From: Ania Dorocinska <Ania.Dorocinska@planning.nsw.gov.au>
Sent: Wednesday, 11 December 2019 2:01 PM
To: Daniel Williams
Cc: Chris Ritchie; Joanna Bakopanos; Rohan Dickson; Danica
Subject: Biodiversity Assessment - Elizabeth Drive, Cecil Park SSD 8859

Further to our telephone conversation on Friday 6 December 2019 I want to summarise the information that is required to be included in the Biodiversity Development Assessment Report (BDAR):

drg no.		date		issue	
DA04		07/09/2018		DA

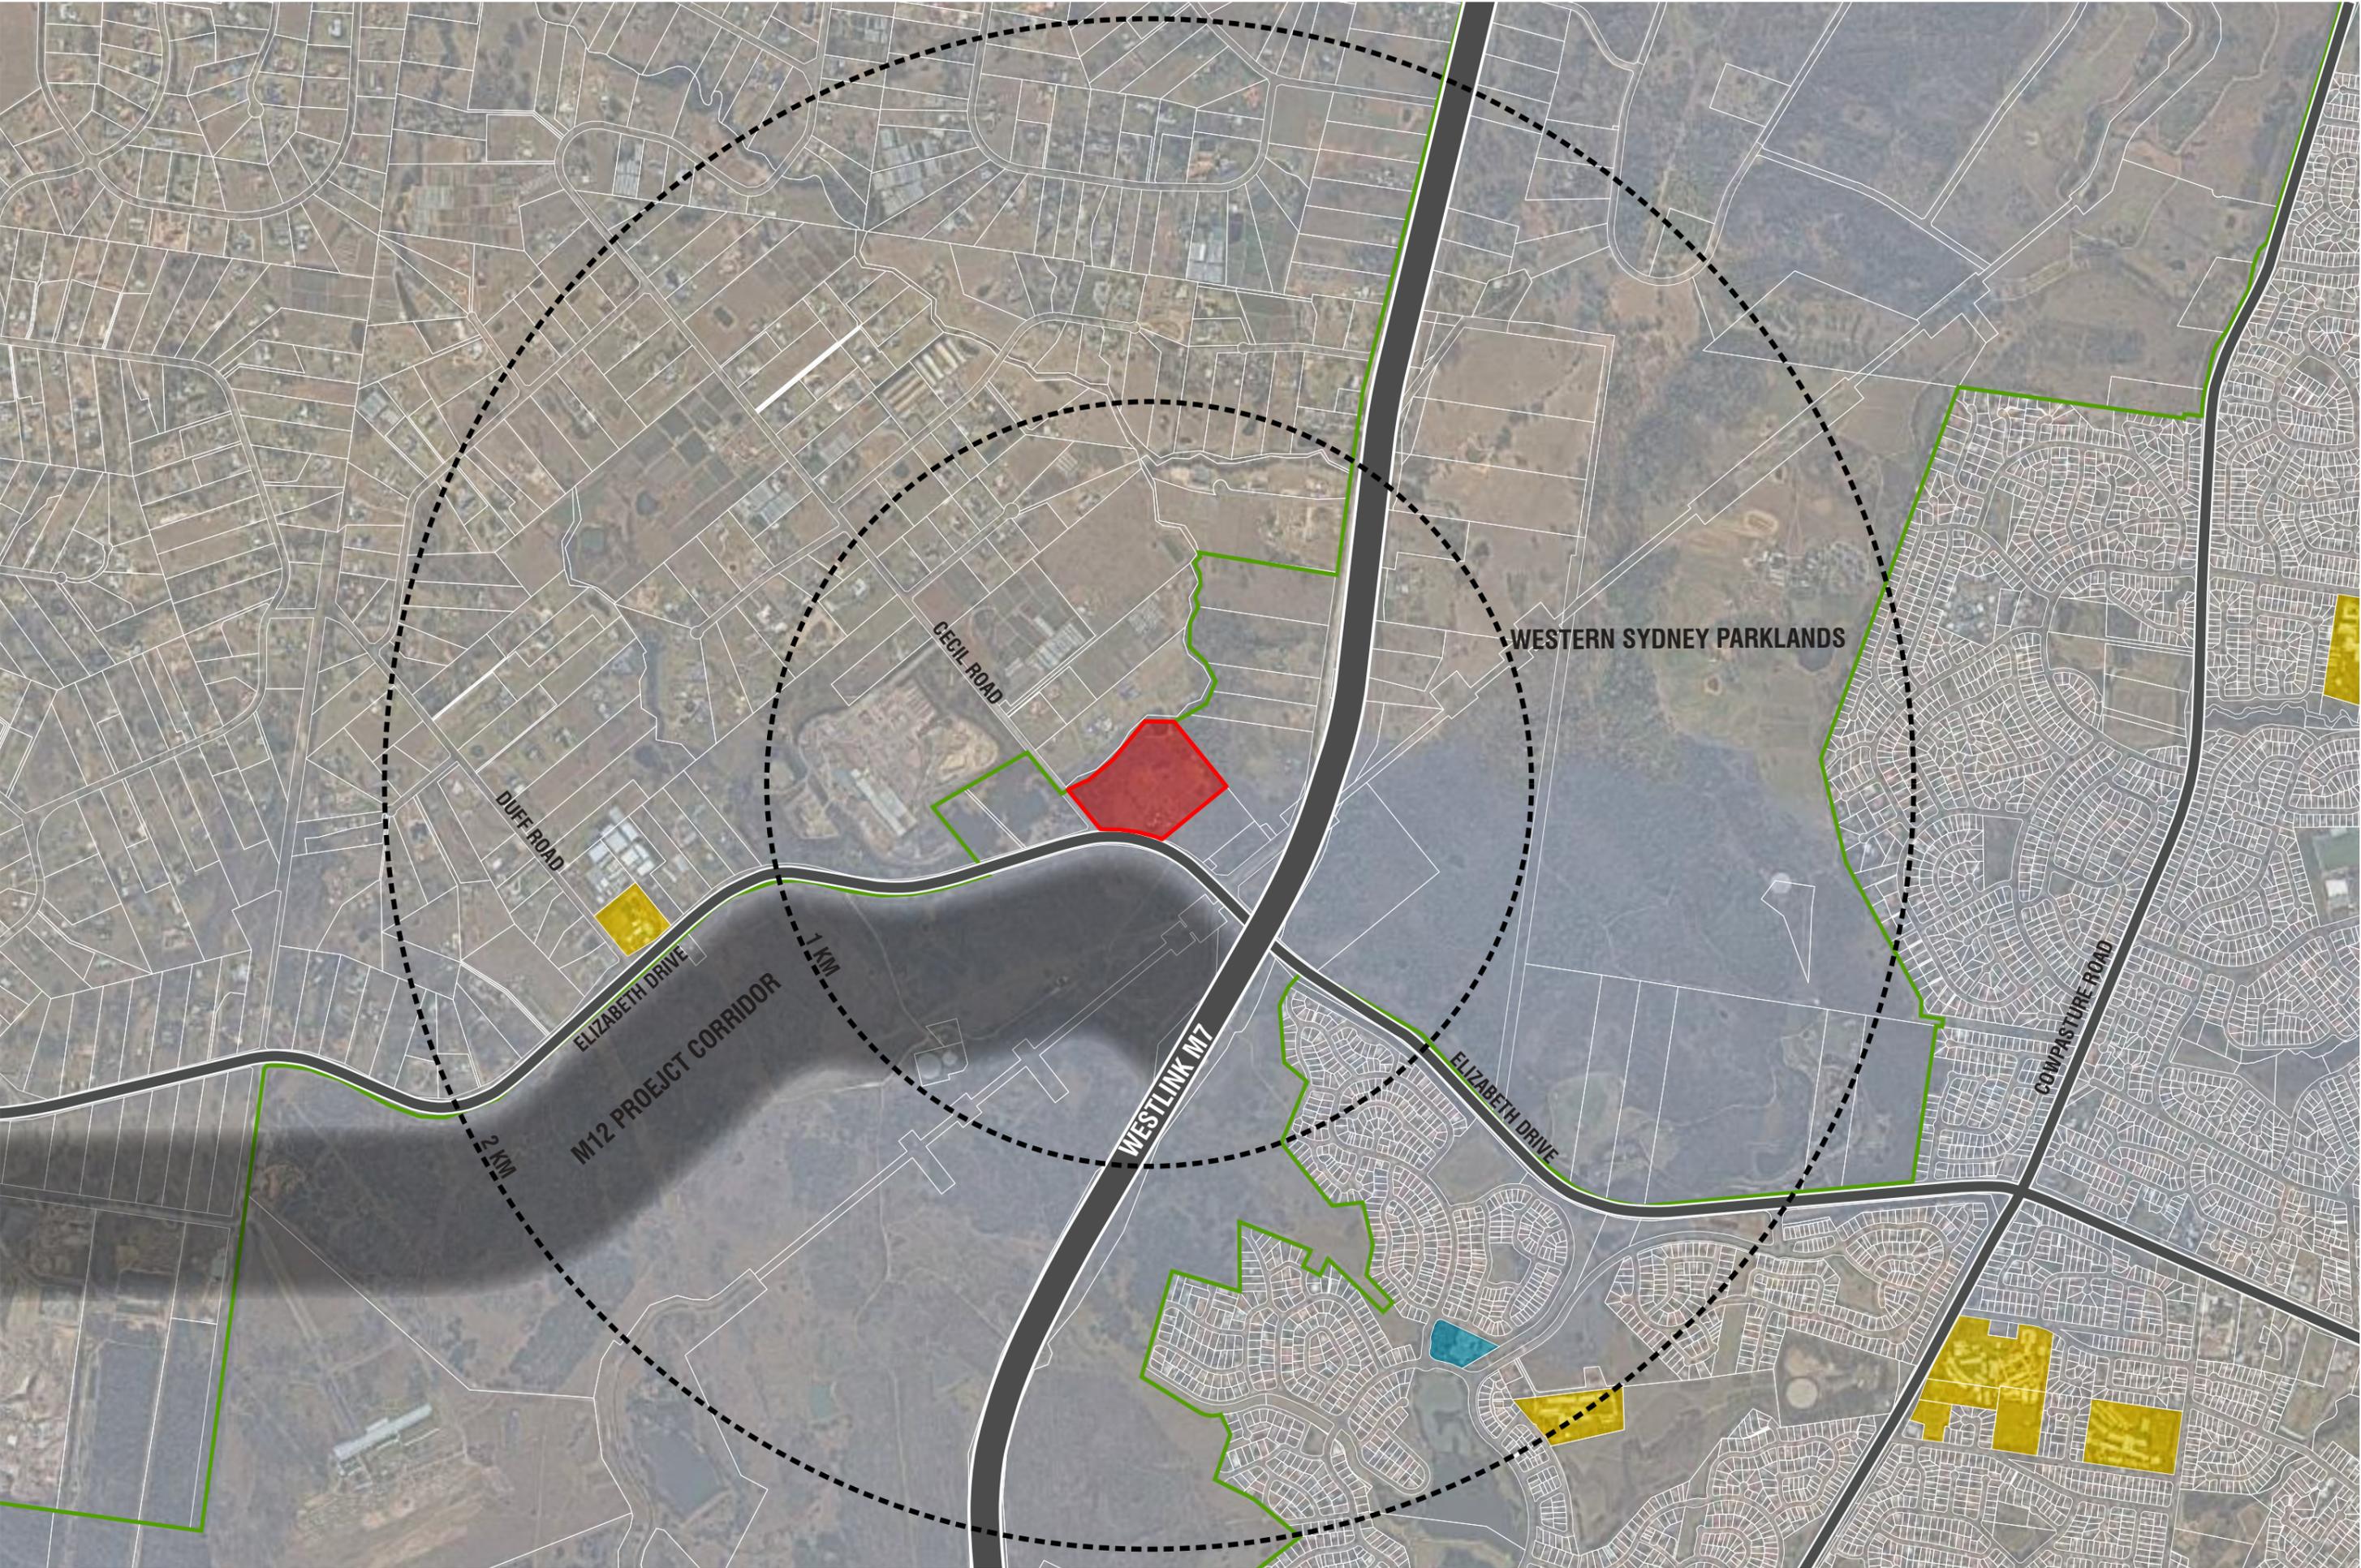
The site includes CPW critically endangered ecological community (CEEC), whereby the BDAR is required to demonstrate attempts made to avoid and minimise impacts where possible, if impacts are in fact unavoidable, then adequate justification is required to be provided. It is my understanding that the reports submitted to date have not demonstrated attempts to avoid and minimise impacts, furthermore, the assessments have not adequately justified that the impacts on the CEEC are unavoidable.

The aerial image below is marked up (in red) to show the areas of vegetation which you can consider avoiding (directly and indirectly) by the development or by any associated infrastructure or bushfire requirements.
